Application for a non-material amendment following a grant of planning permission

OUTLINE APPLICATION (ACCESS LAYOUT, SCALE, APPEARANCE) FOR DEMOLITION OF STABLES AND ERECTION OF RESIDENTIAL DEVELOPMENT FOR 3 SELF-BUILD / CUSTOM BUILD DWELLINGS INCLUDING ASSOCIATED WORKS.

2024/93046

INDICATIVE CROSS SECTION 1:50 @ A1

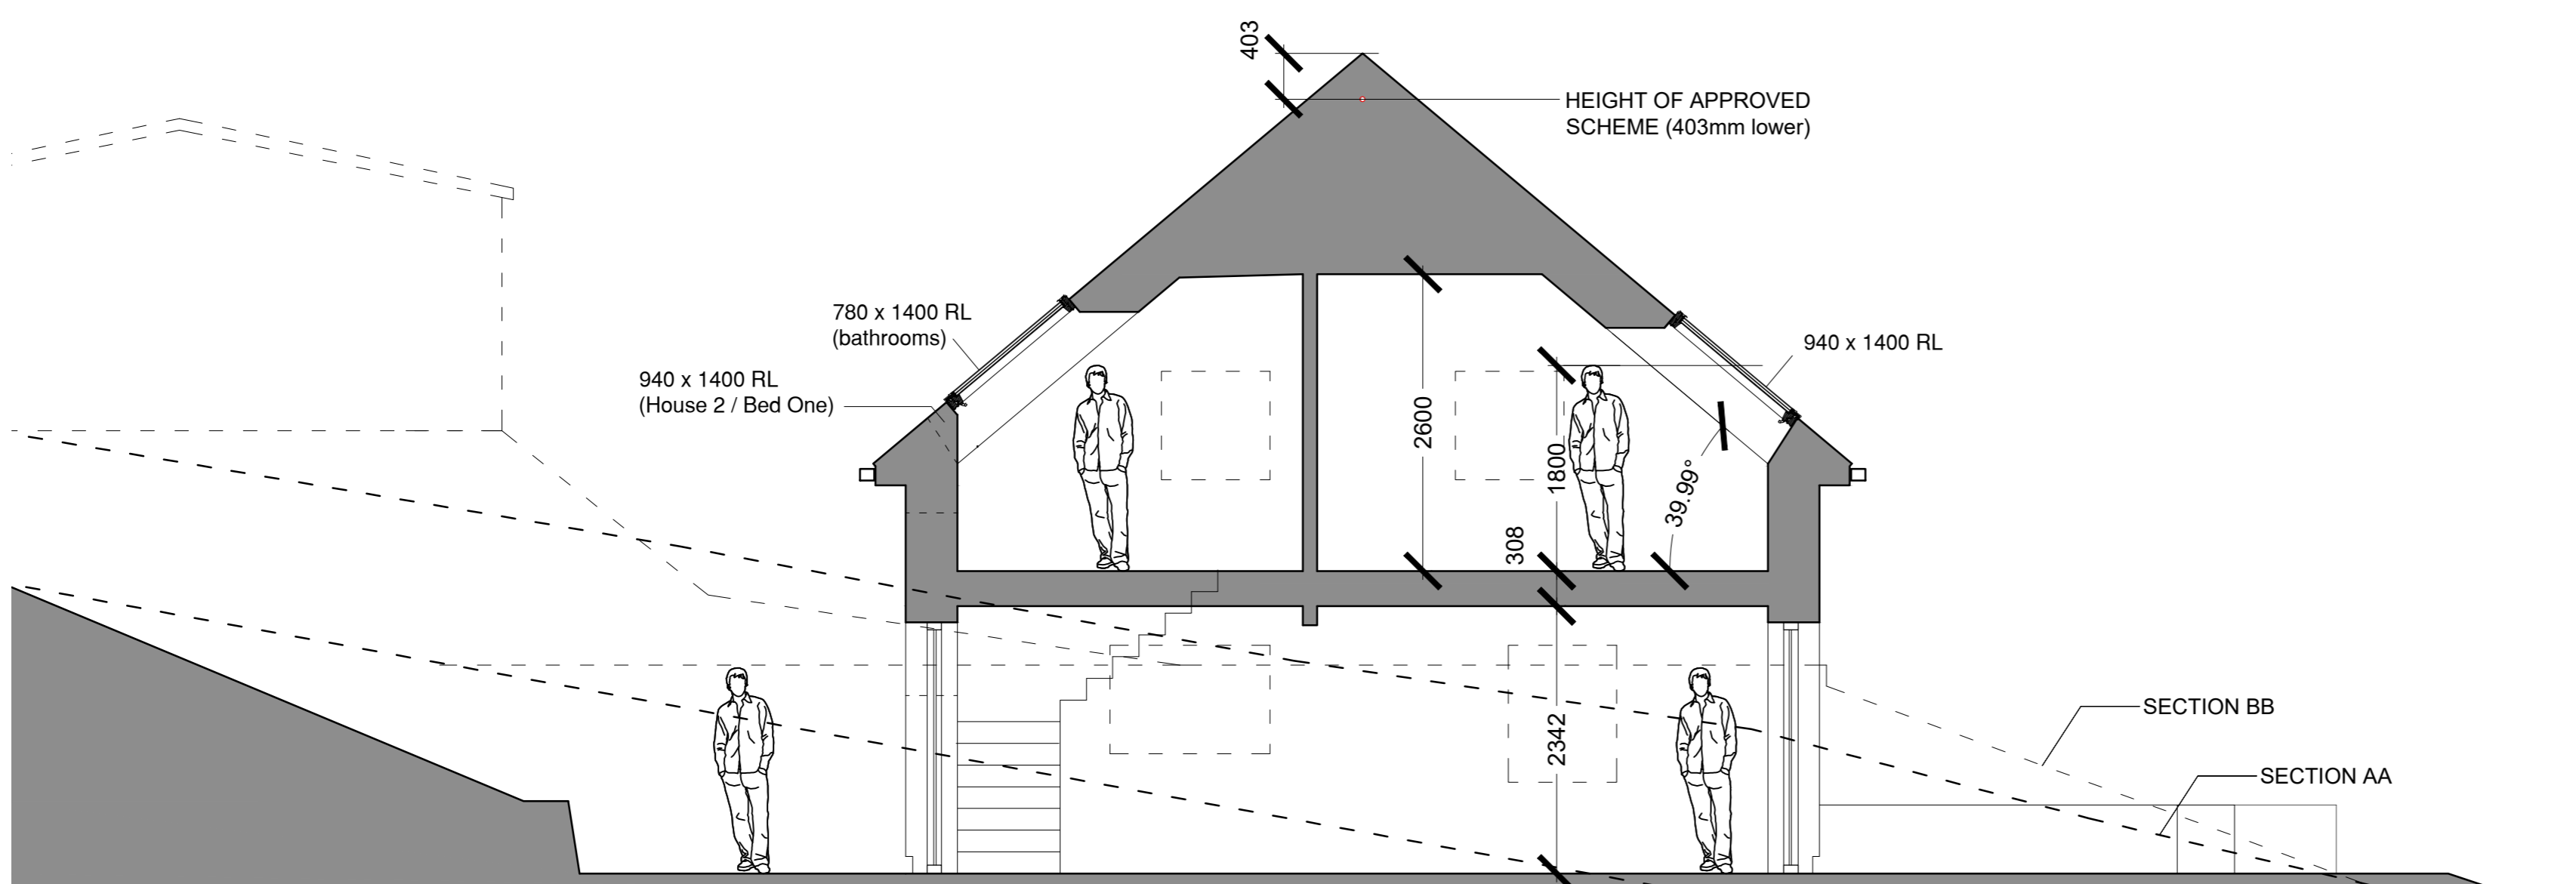
1. FENESTRATION - MINOR CHANGES TO LOCATION AND DETAIL
DOORWAYS - MINOR CHANGES TO LOCATION AND DETAIL
2. INTERNAL LAYOUT - MINOR CHANGES WHICH HAVE NO ADVERSE EXTERNAL IMPACT.
3. MINOR INCREASE IN RIDGE HEIGHT

1. FENESTRATION/DOORS - CHANGES FOLLOWING PASSIVHAUS MODELLING RE OVERHEATING AND DAYLIGHTING ISSUES.
2. TO PROVIDE PROTECTED MEANS OF ESCAPE FROM FIRST FLOOR AND TO OPTIMISE ACCESSIBILITY, FUTURE PROOFING / DISABLED LIVING.
3. TO INCREASE RIDGE HEIGHT TO ACCOMMODATE INCREASED INSULATION TO COMPLY WITH PASSIVHAUS CERTIFICATION REQUIREMENTS.

AND TO OPTIMISE PHOTOVOLTAIC OUTPUT BY INCREASING ROOF PITCH.
